# CITY OF ALBUQUERQUE

October 22, 2021

**RE: 5400 Menaul Blvd NE**  
**Grading and Drainage Plans**  
**Engineer's Stamp Date: 09/08/21**  
**Hydrology File: H18D074**

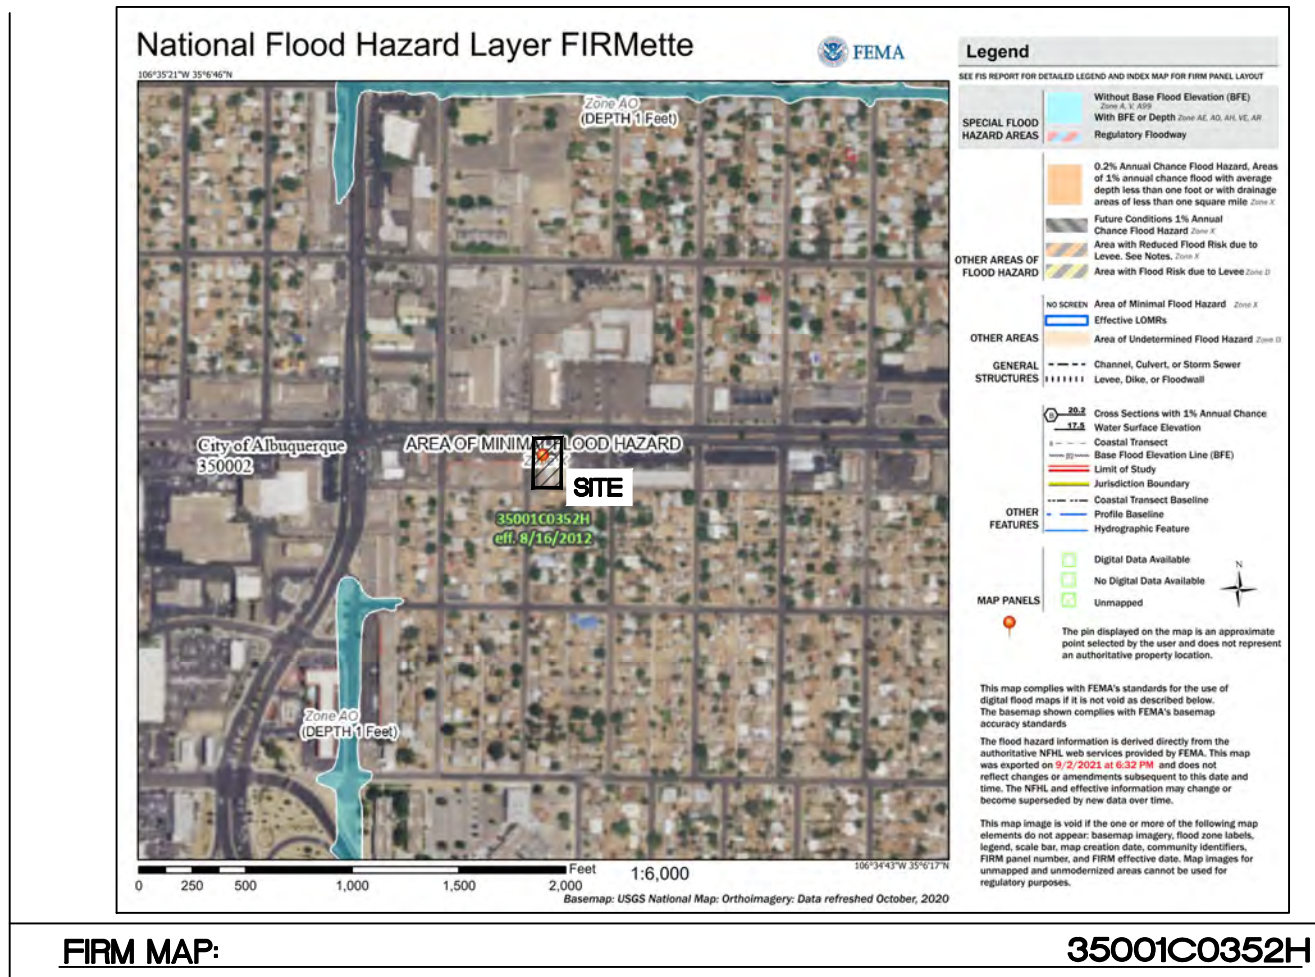
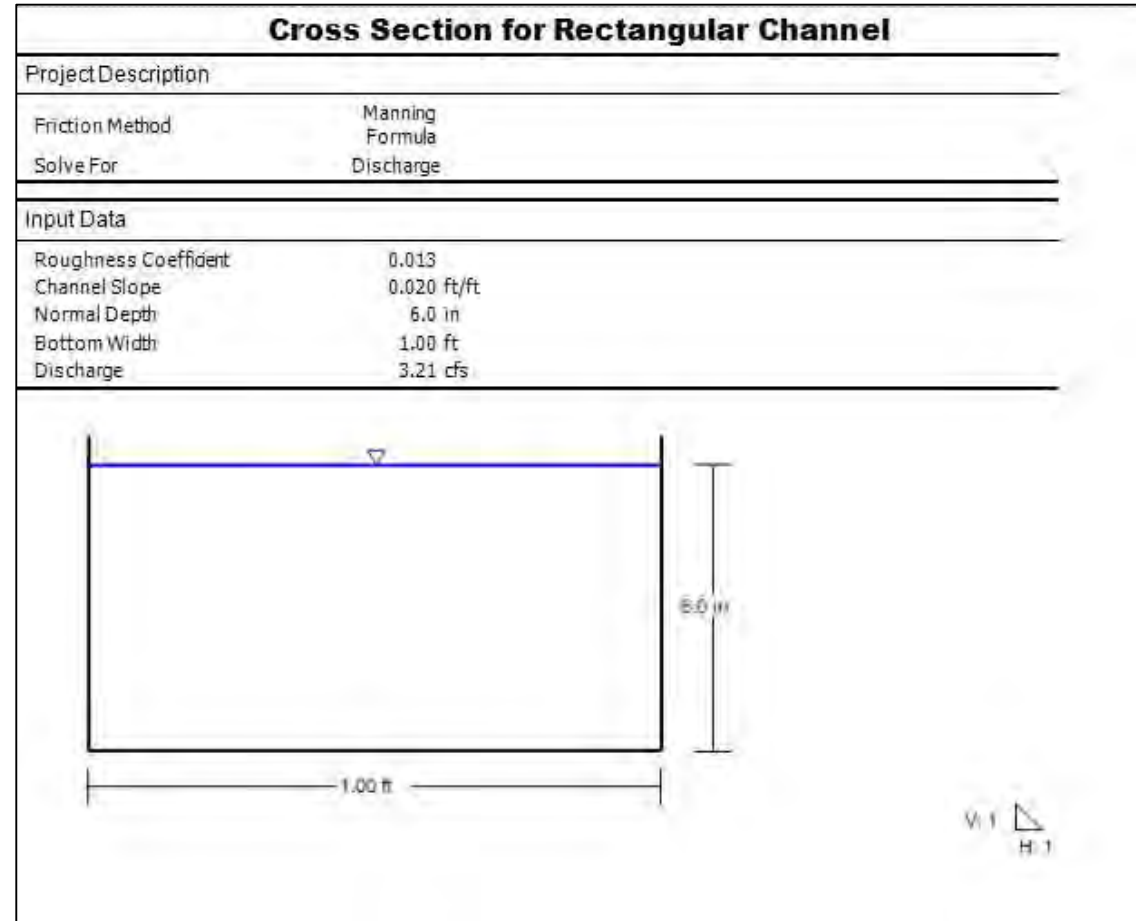
1. Please provide a vicinity map showing the location of the site. Typically this is the Zone Atlas. This can be downloaded in pdf format from the City of Albuquerque's website.
2. Please provide the weir calculations, per DPM Article 6-16(A), for the curb cuts and sidewalk culverts. A coefficient of 2.7 is typically used for the weir equation  $Q = CLH^{2/3}$ .
